STATE OF MAINE
DEPARTMENT OF ENVIRONMENTAL PROTECTION

December 10, 2012

Thank you for submitting the plans concerning vegetation removal and replanting on behalf of Canal Landing, LLC, to the Maine Department of Environmental Protection (Department) for review. The property on West Commercial Street is the prospective site of the relocated Portland Yacht Services. The use associated with this business is considered to be at least partially functionally water dependent, thus requiring development directly adjacent to and/or over the resource.

The proposed plans for the relocation of the Portland Yacht Services, requires a great deal of vegetation removal, not only for the siting of structures, parking and access, but also for the potential need for site remediation of contamination from past uses. This clearing would exceed the provision found at 38 MRSA § 439-A(6)(C), which states that "selective cutting of no more than 40% of the trees 4.5 inches or more in diameter, measured at 4 1/2 feet above ground level, is allowed in any 10-year period . . ."

Title: **PHASE I LANDSCAPE PLAN**

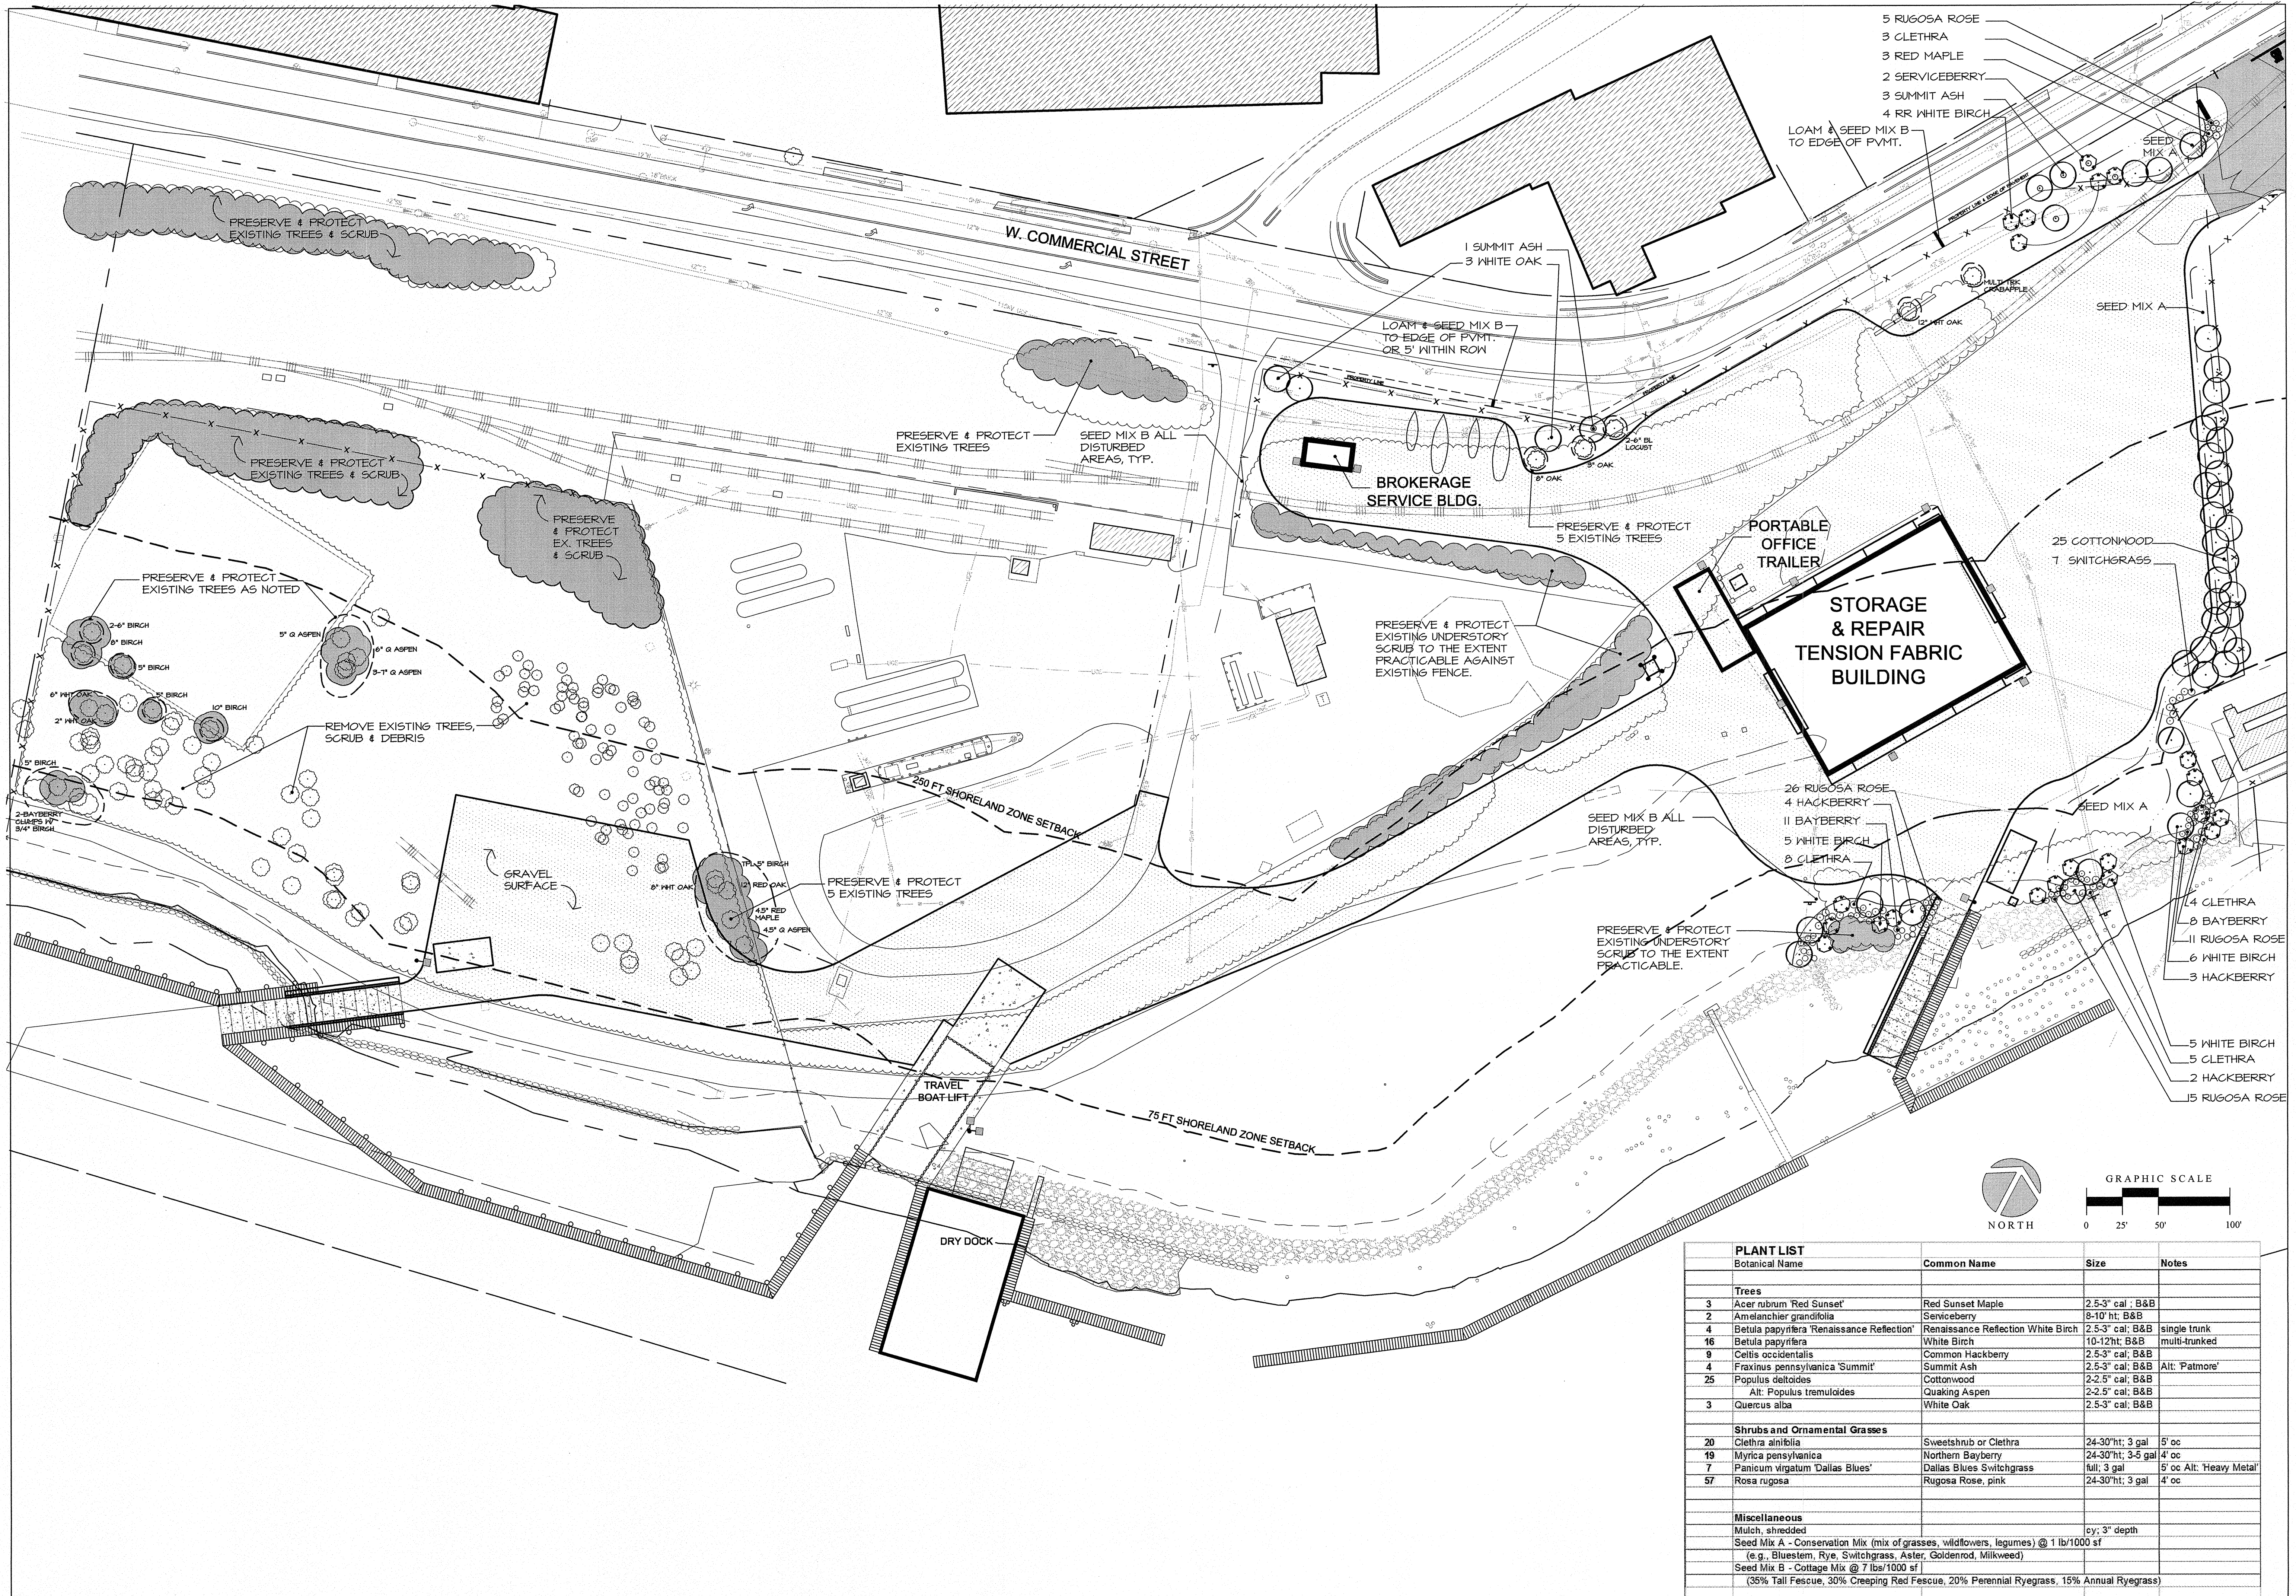
The plan and accompanying letter submitted to the Department includes calculations concerning the number of existing trees over four and one half (4.5) inches in diameter, the number of those trees to be removed, and the number of trees that will be replanted. Currently, the site contains 152 trees over 4.5 inches in diameter, measured at four and one half (4 ½) feet above ground, within the 250 foot shoreland zone.¹ The proposal aims to remove 137 trees, 4.5 inches or more in diameter. Under the 40% provision, 61 trees would be allowed to be removed. This would mean 91 trees would need to be retained. The plan calls for 15 of the trees 4.5 inches or more in diameter to be retained, and the landowner proposes to plant 78 additional trees which would result in a net removal of approximately 39 percent of the trees in the shoreland zone. Along with the tree planting, the landscaping plan also proposes to plant additional vegetation.

When working with municipalities on replanting plans, the Department generally advises that native vegetation be planted, and under certain circumstances is mandated by law and rule. The plan provided to the Department calls for a significant number of Eastern Cottonwood trees (*Populus deltoids*) to be replanted. Eastern Cottonwood, while not native, has become quite naturalized in Maine. Due to their rather fast growing rate they are good trees for providing windbreaking properties, they grow well along rivers, and are good trees for providing shading. Through the municipal permitting process, the City of Portland may require the planting of native vegetation, but the Department would not find issue with allowing the planting of these trees in this particular instance.

In any replanting effort, especially of this magnitude, the Department generally recommends that an applicant provide for a three year maintenance plan, which seeks to retain an at least 80 percent survival rate. Again, during the local permitting process this may be something the City of Portland will require as a condition of the permit, but is not mandated by the Department.

Department review of this proposal and accompanying plan finds it to be consistent with the general purposes of the Act. Sufficient vegetation will both be retained and replanted, the use of this property for maritime purposes is strongly supported by the Act, and remediation of contaminated areas will improve the site overall.
